DECISION DELEGATED TO HEAD OF PLANNING

Application No: H16-0891-22 **Applicant:** Naylor Farms

Proposal: Details of finished floor levels. (Condition 5 of H16-0959-21)

Location: Land To South Of Low Road/Rangell Gate (B1165) And East Of A16 Spalding

Project PLANT BASED PROTEIN EXTRACTION FACILITY		
Address NAYLOR FARMS RANGELL GATE, SPALDING LINCOLNSHIRE		
Client NAYLOR FARMS		
Drawing PROPOSED SITE PLAN		
Date SEPT 2021	Scale 1:500 @ A1 - 1:1000 @ A3	
Project No. 3899	Drawing No. P01	Revision A

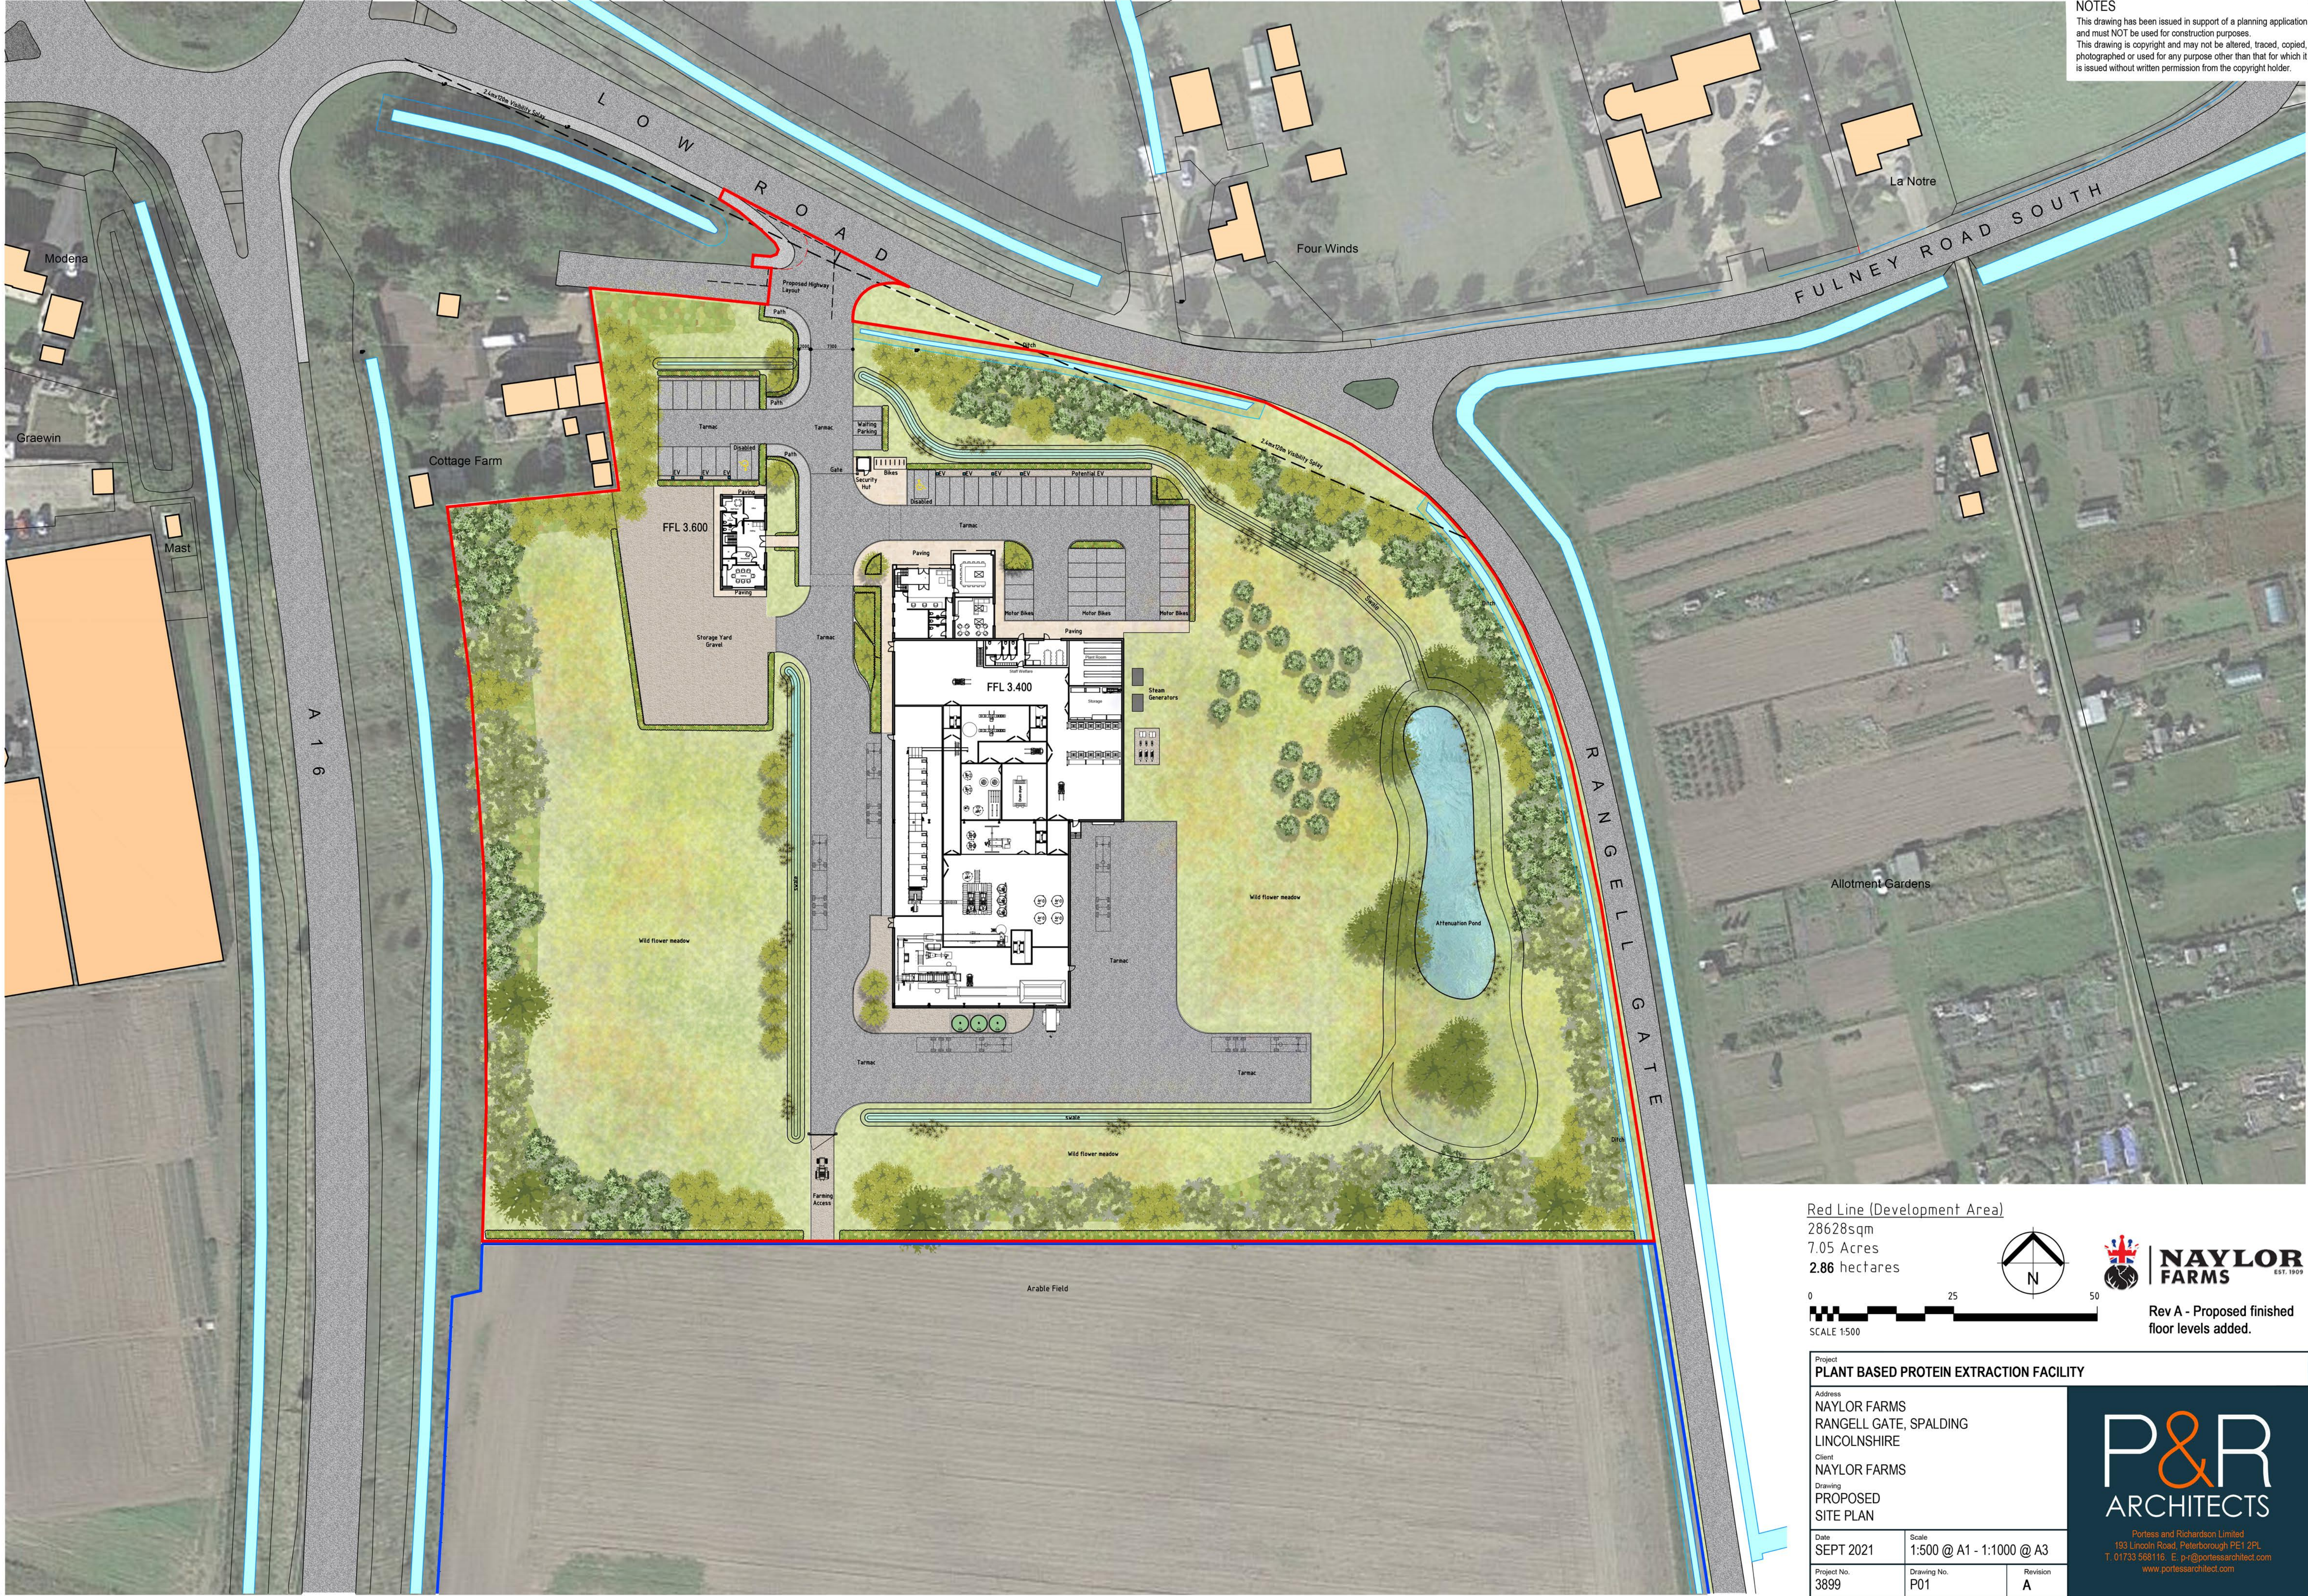
The submitted plan indicates that the floor level of the main building would be 3.4m AOD and the separate office building 3.6m AOD.

Based on the levels survey submitted with the original application, these proposed levels accord with the requirements of Condition 5.

Neither building would be raised greater than around 600mm higher than existing and given the separation distance to any neighbouring property (approx. 28m to Cottage Farm and 57m to Four Winds at their closest points) it is not considered that there would be an adverse amenity impact by way of overlooking or being overbearing.

Taking the above into account, it is considered that Condition 5 of H16-0959-21 can be discharged.
